DECISION DELEGATED TO HEAD OF PLANNING

Application No: H16-1096-25 **Applicant:** Mr A Piccaver

Proposal: Replacement of windows at first floor level, access door to ground floor & removal of window to ground floor

Location: 2 & 2a Sheep Market Spalding Lincolnshire

REV	DESCRIPTION	DATE
A	Proposed ground floor plan added	11.11.2025
PROJECT: REPLACEMENT WINDOWS		
DRAWING: EXISTING FLOOR PLANS, EXISTING & PROPOSED ELEVATIONS, SITE LOCATION PLAN, PROPOSED BLOCK PLAN		
SIZE: A1	CLIENT: Mr A. Piccaver	
SCALE: as labelled	DRAWING BY: JC	SHEET: 0518/25/01A

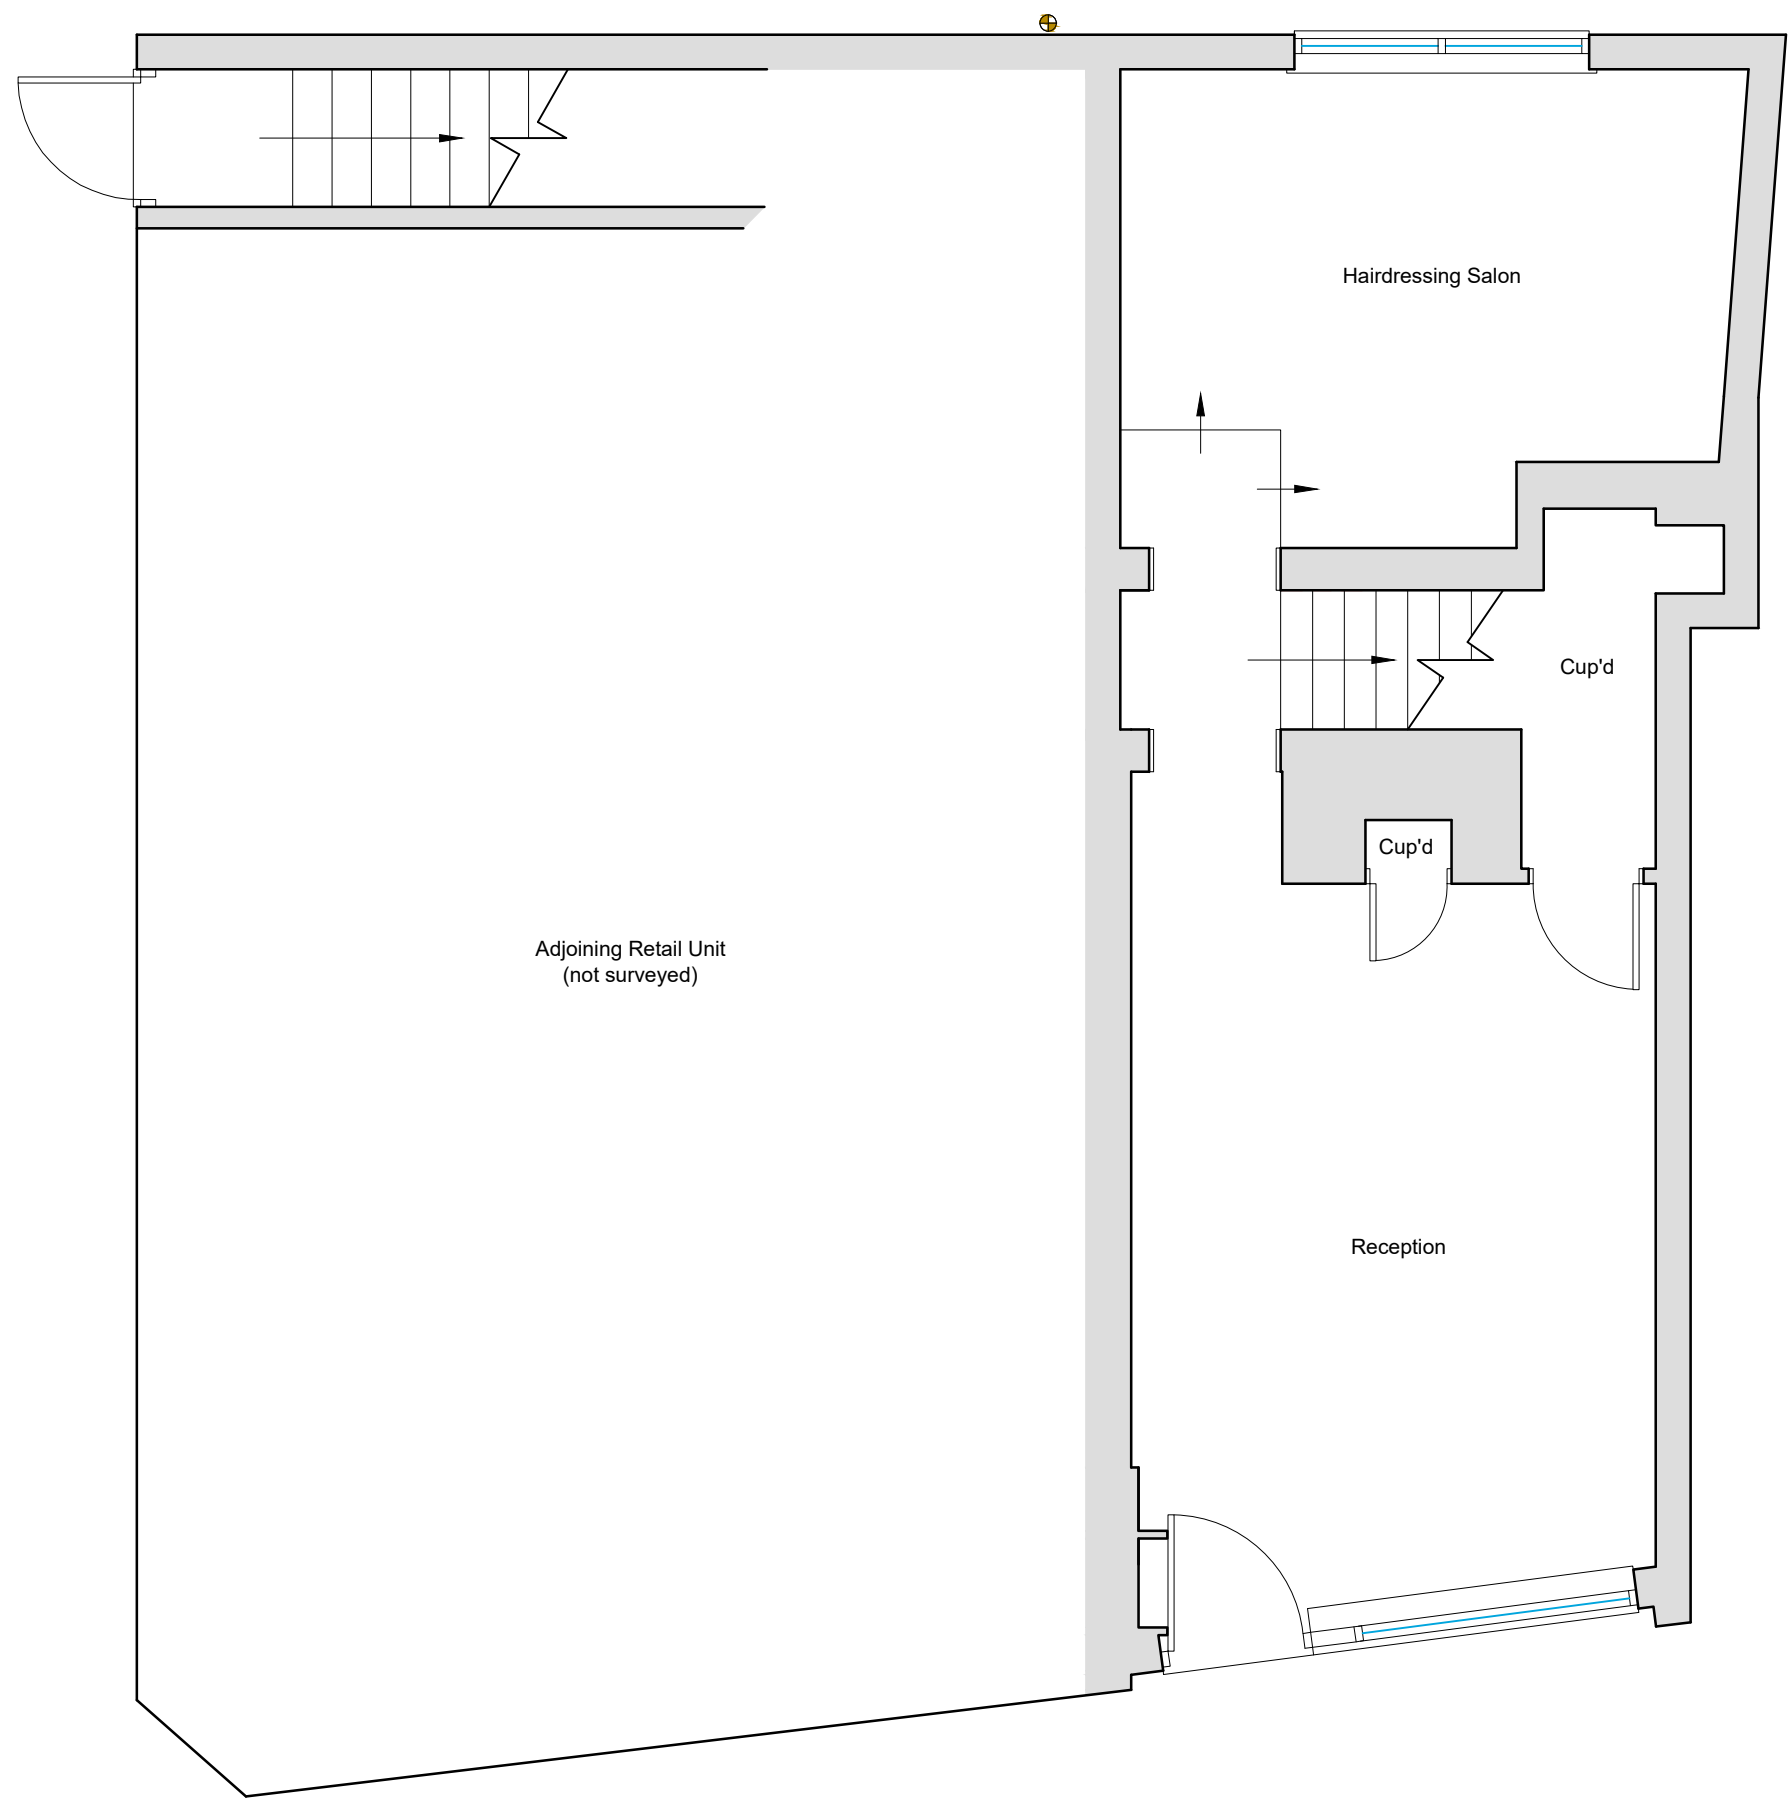
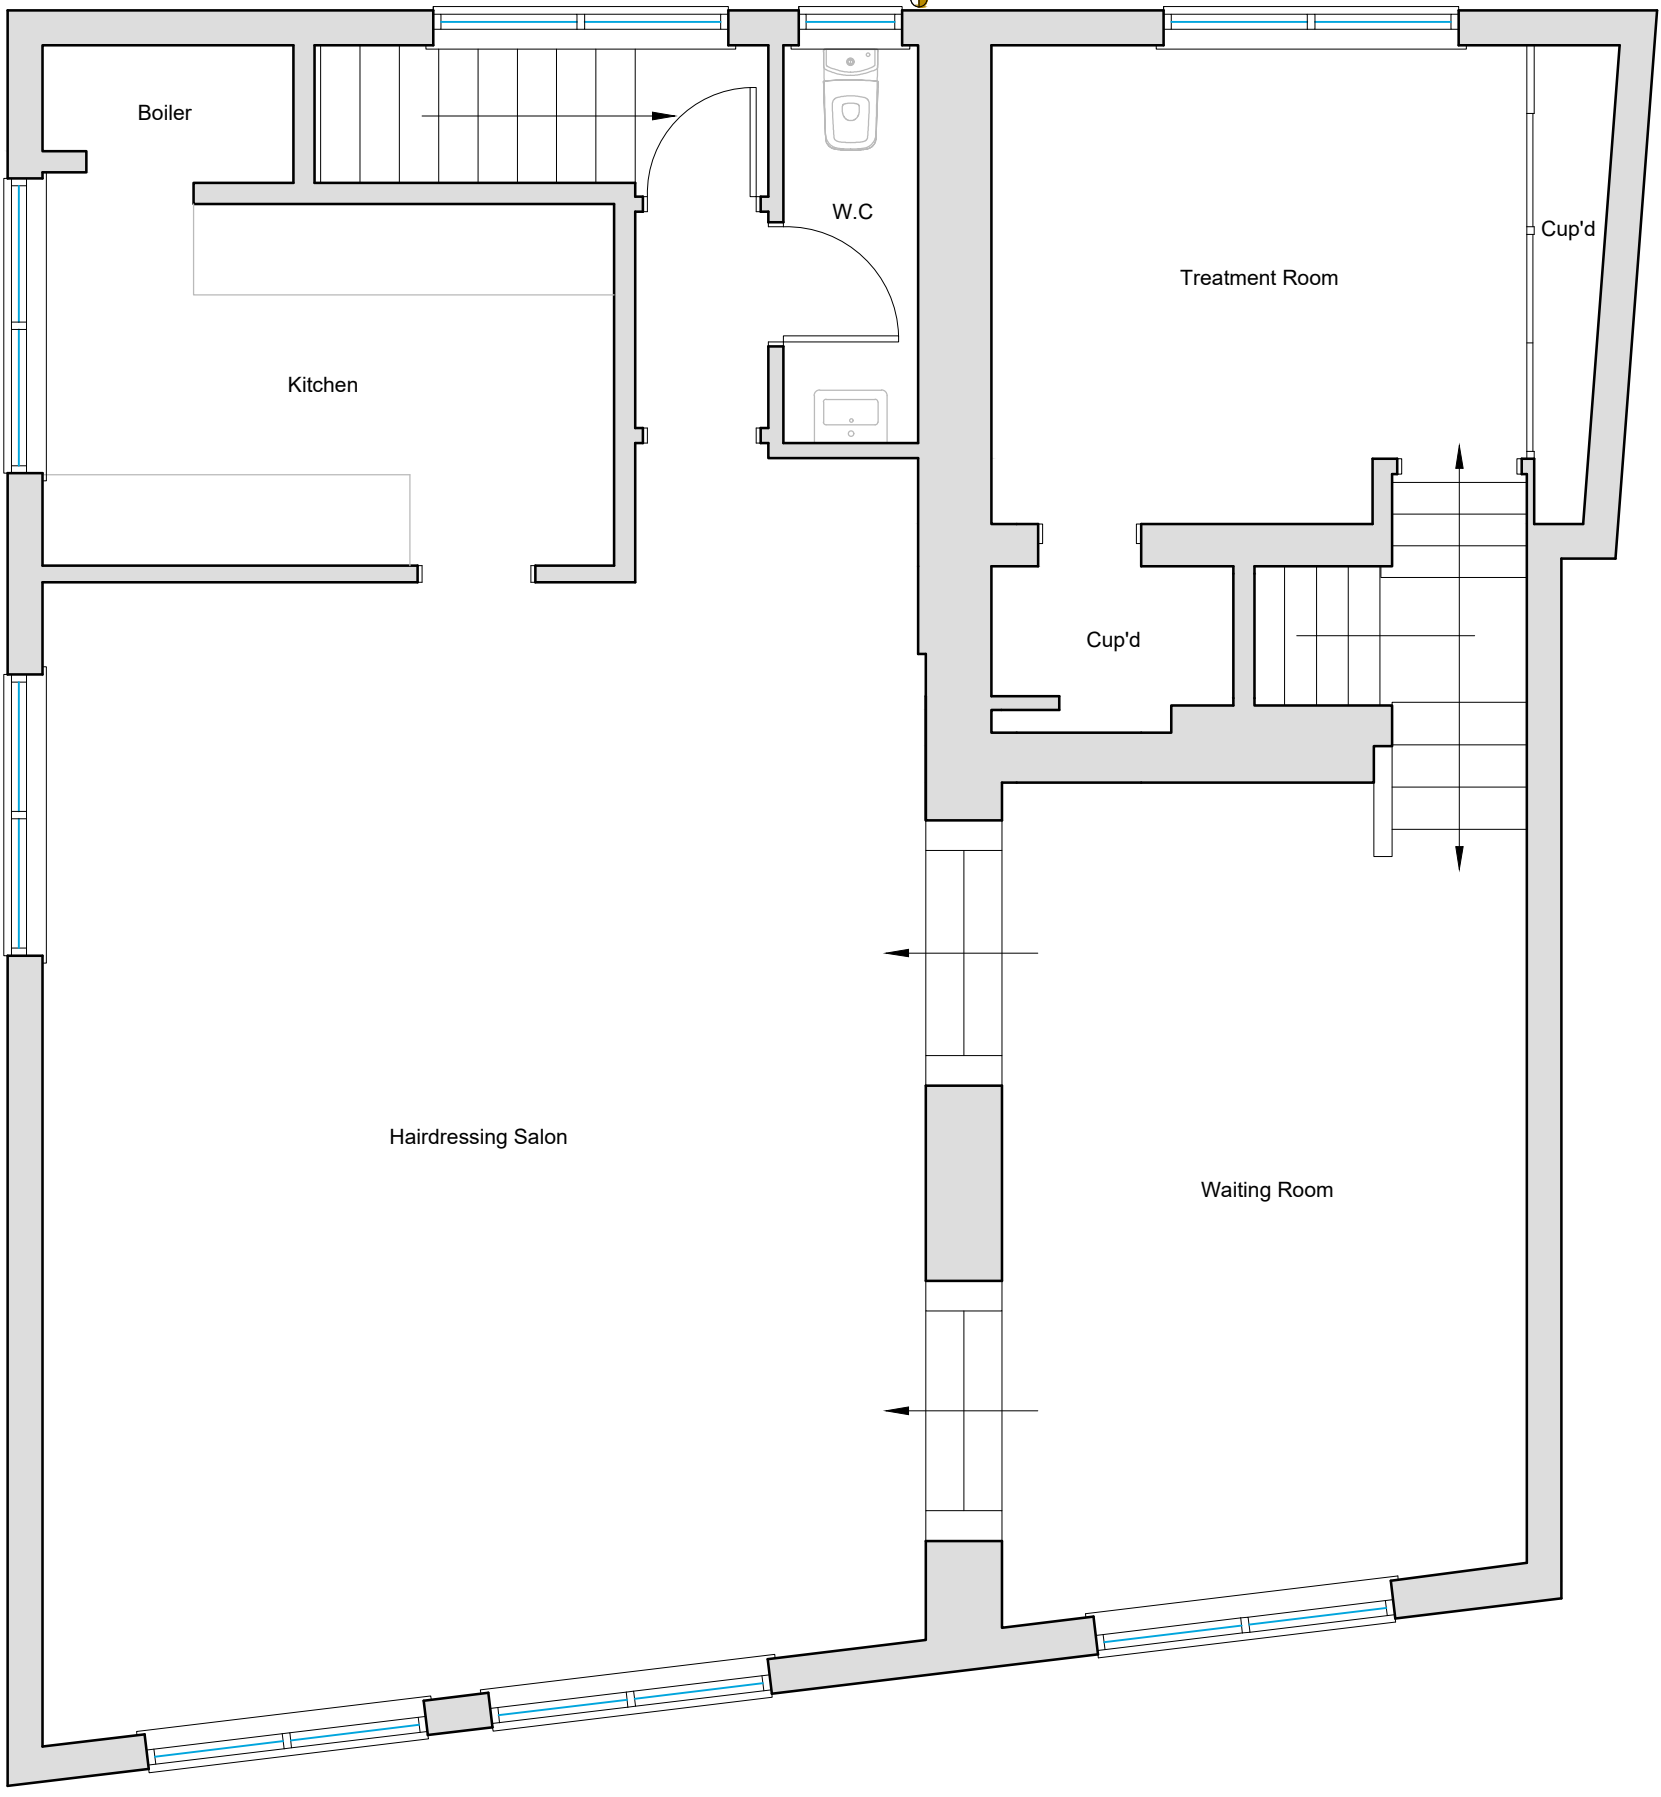
Spalding and District Civic Society: There are no frame or casement details of the windows proposed. Timber would be preferable to UPVC in such an important position in the town. The existing fenestration is unfortunate but there is no point in trying to make it look traditional in appearance.

Conservation Officer: As this application is solely for the replacement of windows, and situated in a prominent, conservation area location, full details of the proposed replacement windows shall be required prior to a decision. As the application currently stands, it is not possible to make a reasoned and informed planning decision with the detail available.

The application seeks consent to install flush casement UPVC windows at the first-floor level of the building and to replace a ground floor timber door on the north-eastern side elevation with a grey composite door. The windows at the ground floor level would remain unchanged.

It is also proposed to remove a window on the rear (south-eastern) elevation and infill this area. It is presumed that this area is proposed to be infilled with brickwork; however, the submitted plans do not conform this. As the rear elevation is not visible from the street scene nor is it prominent within the Conservation Area, the proposed infilling of the window is considered to be acceptable, providing the infilled area match the existing elevation materials as closely as possible.

Currently, the windows on the front (north-western) elevation feature timber frames, the windows on the side (north-eastern) elevation feature UPVC frames, and the windows on the rear (south-eastern) elevation feature metal frames. The side and rear windows are not highly visible from the street scene. According to the submitted Planning Statement, as the windows are at the first-floor level, they are not in the "immediate view of people passing by"; however, the first-floor windows particularly at the front of the building are still clearly visible.

Policy 29 B(3) states that new development should seek to retain and reinforce local distinctiveness with reference to materials, amongst other factors. UPVC is not considered to be a local vernacular material. The council's conservation officer has asked for further information to justify the proposals; however, the only additional information received has been an updated plan clarifying the existing materials within the windows.

The proposed use of UPVC is not considered to be acceptable in this instance as the proposal would be contrary to Policy 29 of the Local Plan and Paragraph 215 of the NPPF. For example, Policy 29 states that new development should seek to retain and reinforce local distinctiveness with reference to materials. UPVC is not considered to be a local vernacular material. It is considered that the proposed use of UPVC would result in less than substantial harm to the character and appearance of the Conservation Area - albeit adverse harm would still result. It is not considered that there would be public benefits from the proposed change to UPVC windows and as such, the proposal would not accord with Paragraph 215 of the NPPF. It is considered that there is insufficient justification for the proposed change to UPVC windows and as such there are insufficient material considerations to weigh in weigh of the proposals due to the adverse impact that would arise to the surrounding built heritage environment. As such, the planning balance is against the development.
